Environmental Health Consultation Response

To	Harry Chalk
Date	26-02-2026
Planning Ref	BR/2/26/PL
Site Description	37 Glamis Street Bognor Regis West Sussex PO21 1DJ
Date of Application	2026-02-16 00:00:00
Category	Application
Recommendation	~~No Objection~~ No Objection – with conditions ~~Objection~~ ~~Holding Objection~~

BR/2/26/PL

SITE
37 Glamis Street, Bognor Regis, PO21 1DJ
DRAWING TITLE
Proposed Floor Plans

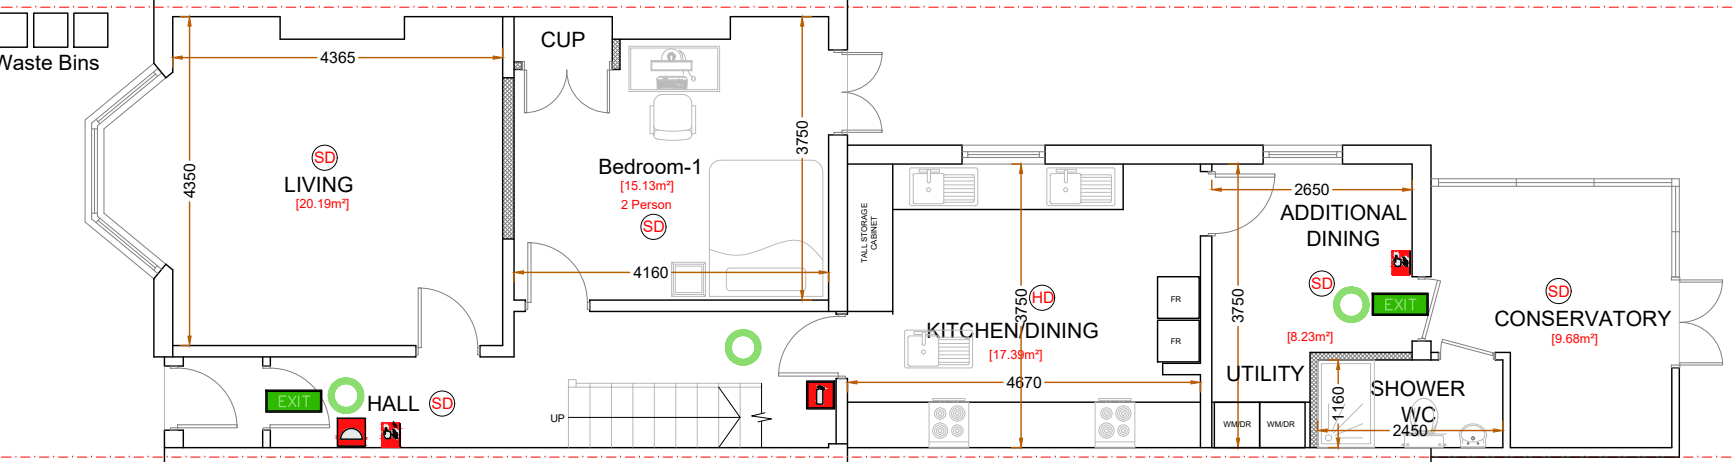
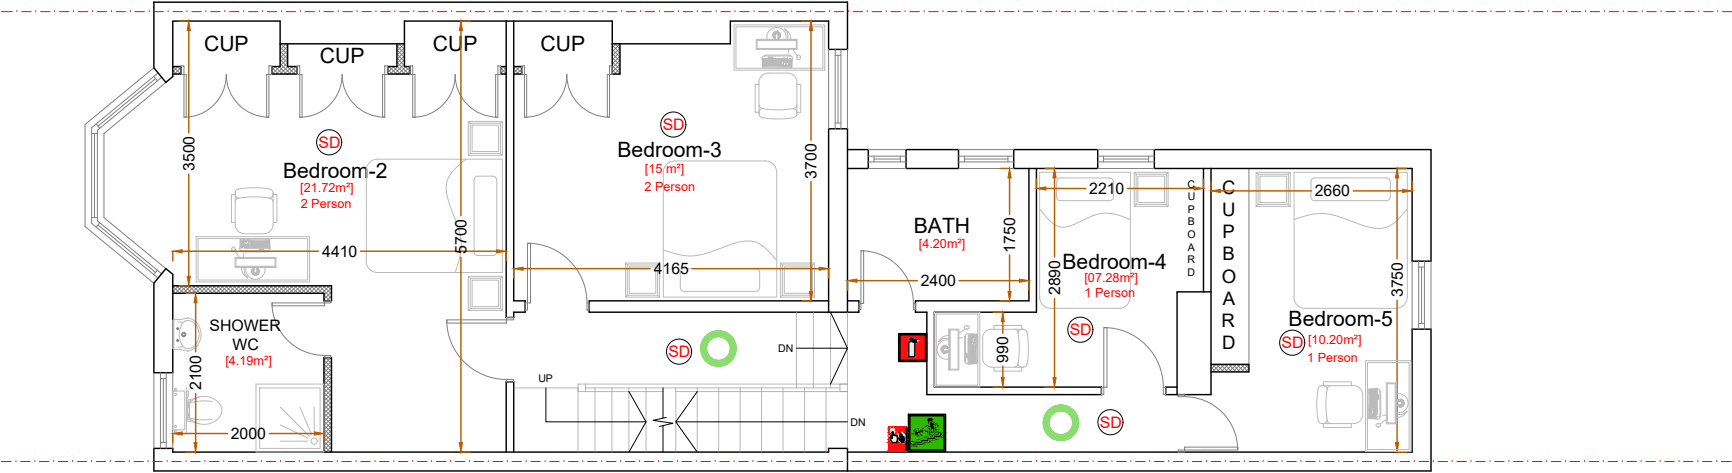
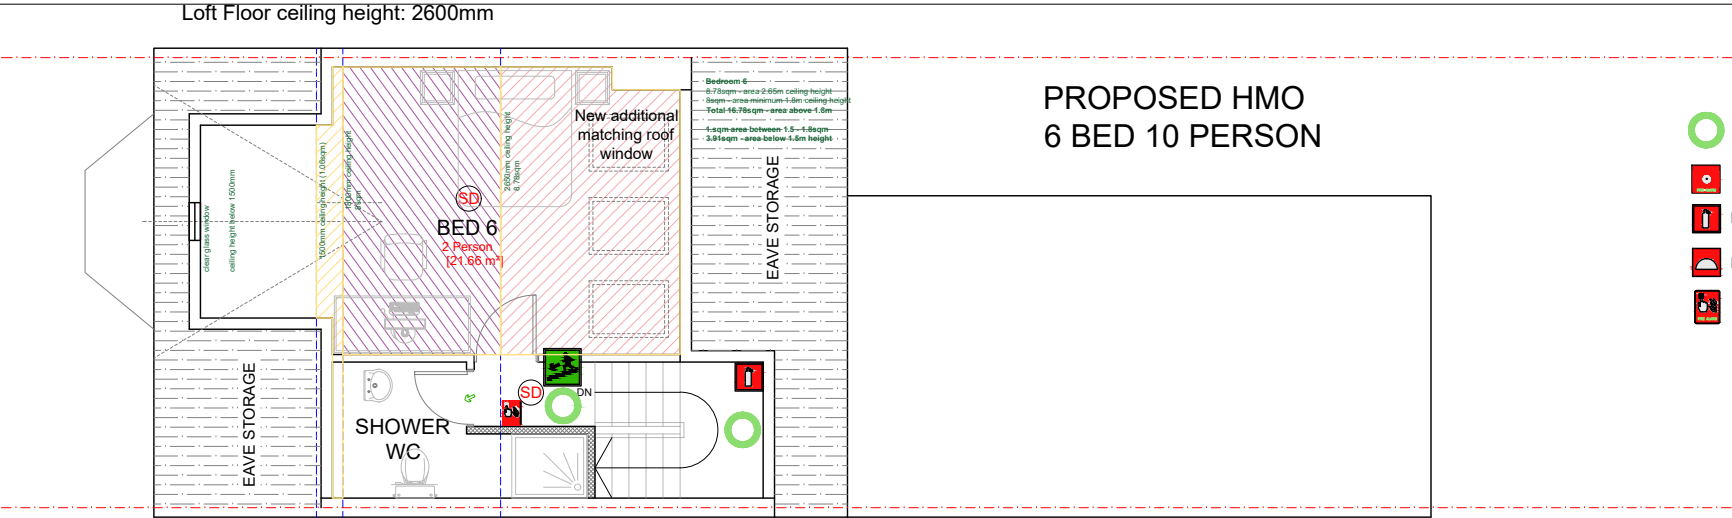
I have reviewed the above application and while I do not object in principle, I am concerned about the noise impact this change may have on the adjoining properties. This type of development often results in the occupants using their bedrooms more as living rooms spending much more time in them, this can result in effectively changing the layout of the house to put living spaces adjoining the neighbour's sleeping spaces.

The change of use hereby permitted shall not begin until a scheme for protecting the existing noise sensitive residential dwellings adjacent to the proposed development, has been prepared by a competent person and submitted to and approved in writing by the Local Planning Authority. All works which form part of the scheme shall be completed before the development is occupied and shall be retained and maintained in perpetuity. The scheme shall be designed to achieve a minimum airborne sound insulation value of 50dB (DnT, w + Ctr) for floors/ceilings and 48dB (DnT, w + Ctr) for walls.
